**RE: DOVER ROAD, SANDWICH – PLANNING CONDITION 11 ‘SURFACE WATER DRAINAGE’ – Response to KCC letter received 8<sup>th</sup> January 2021 (Ref: DDC/2020/082031)**

This statement has been prepared to address the comments raised by KCC on 8<sup>th</sup> January 2021 (Ref: DDC/2020/082031) and also the subsequent pre-application meeting on Friday 29<sup>th</sup> January 2021.

Drawing No: CON599-3200

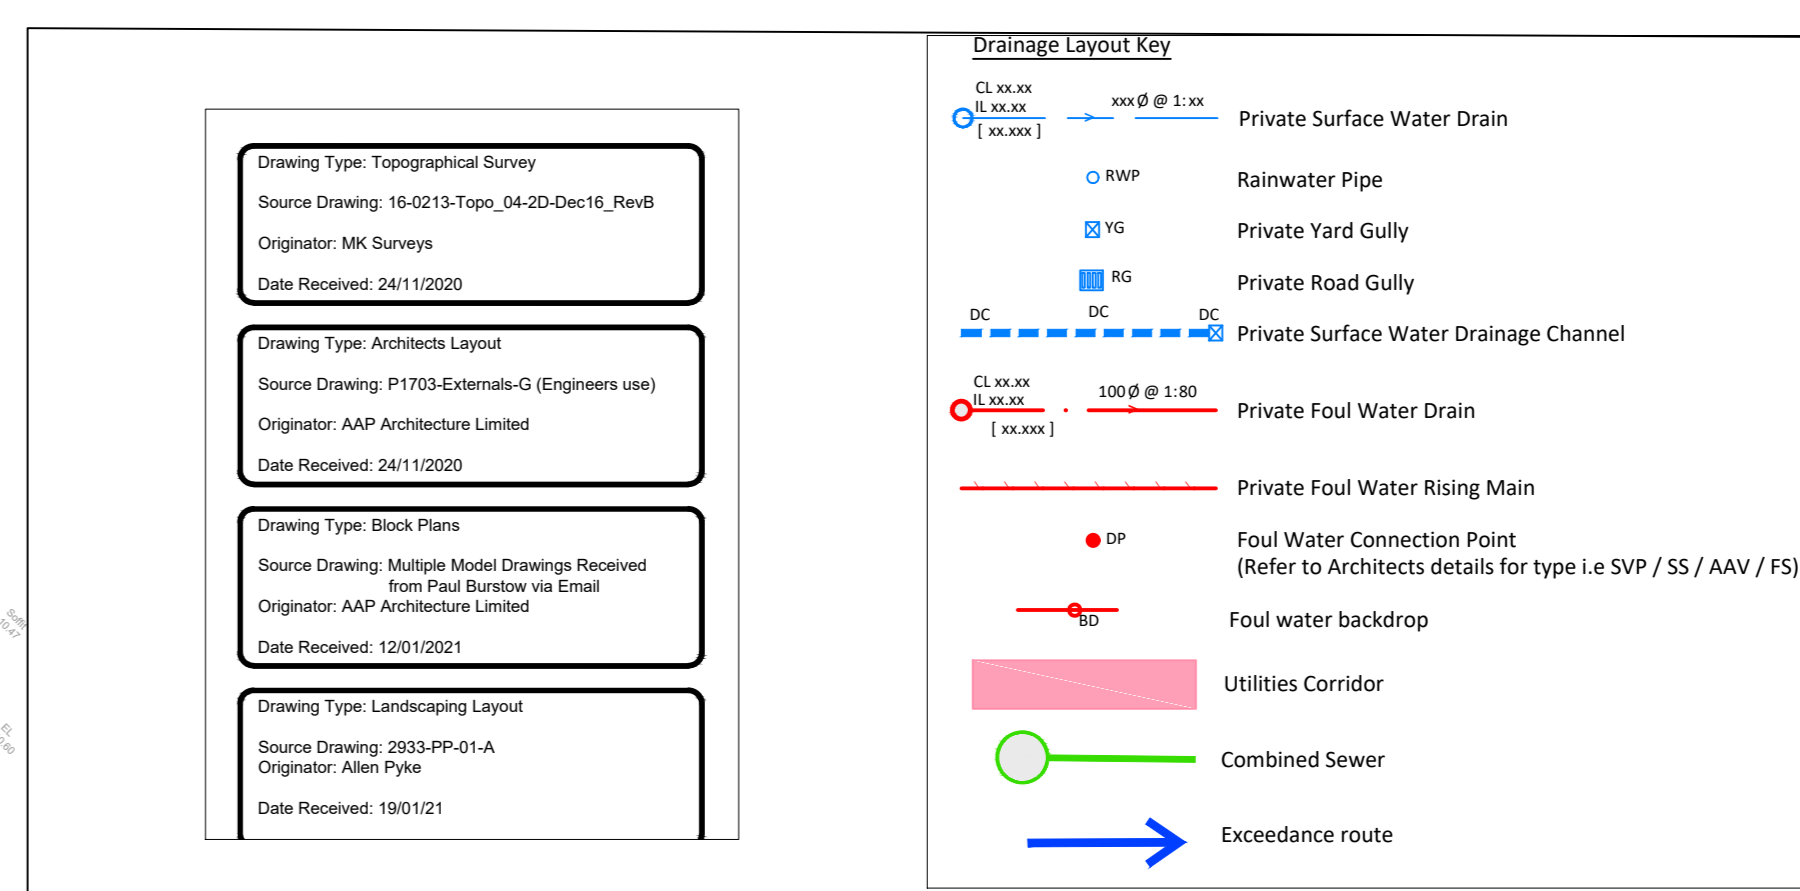
3. The scheme presented at the full planning stage proposed for the outfall to be situated at the southern most point of the site, within a corridor of open space. The latest Drainage Layout drawing (CON599-3200, Revision P1) now proposes an outfall that transects under plot 12's driveway and garden before connecting to the ditch. It is not clear to us how access and subsequent maintenance can be provided at this location and would advise for any new outfall to be situated within an open space corridor, outside of 3rd party land.

4. The Drainage Layout drawing (CON599-3200, Revision P1) shows a large cellular tank in the green space area. We note that three trees are proposed to be situated over the tank. The LLFA advise against the planting of trees close to or over below ground features to mitigate any potential damage from root development. It is therefore recommended that the tree positions are relocated or suitable protection measures are in place to protect the tank

5. It is understood by the Drainage Statement from Knapp Hicks (14th December 2020) and supporting microdrainage calculations that the design has been tested for storm events up to the 100 +30% climate change. As per our current requirements, we would seek that a climate change value of 40% is applied and a simulation ran to understand the implications of a greater event.

KHP Response: Noted, as agreed at the meeting we have relocated the outfall location to the area south of Plot 7 in 3<sup>rd</sup> party land (this was also the location agreed at the planning submission stage).

KHP Response: Noted, all trees will be positioned outside of the tank extents with appropriate tree root protection measures to prevent future clashes.

KHP Response: As agreed in the pre-application meeting, we have updated the Drawing No CON599-3200 to suit the 1:100 year plus 30% climate change storm (the main difference being the tank has got smaller in the central green area) and have also added the exceedance route for both the 1:100 year 30% & 40% storms onto Drawing CON599-3200.

The expected flood volumes for the extreme events are lower than that discussed at the meeting (approx. 70m<sup>3</sup> during the 40% storm, spread over several locations), we assume that this acceptable as it will not encroach inside properties.
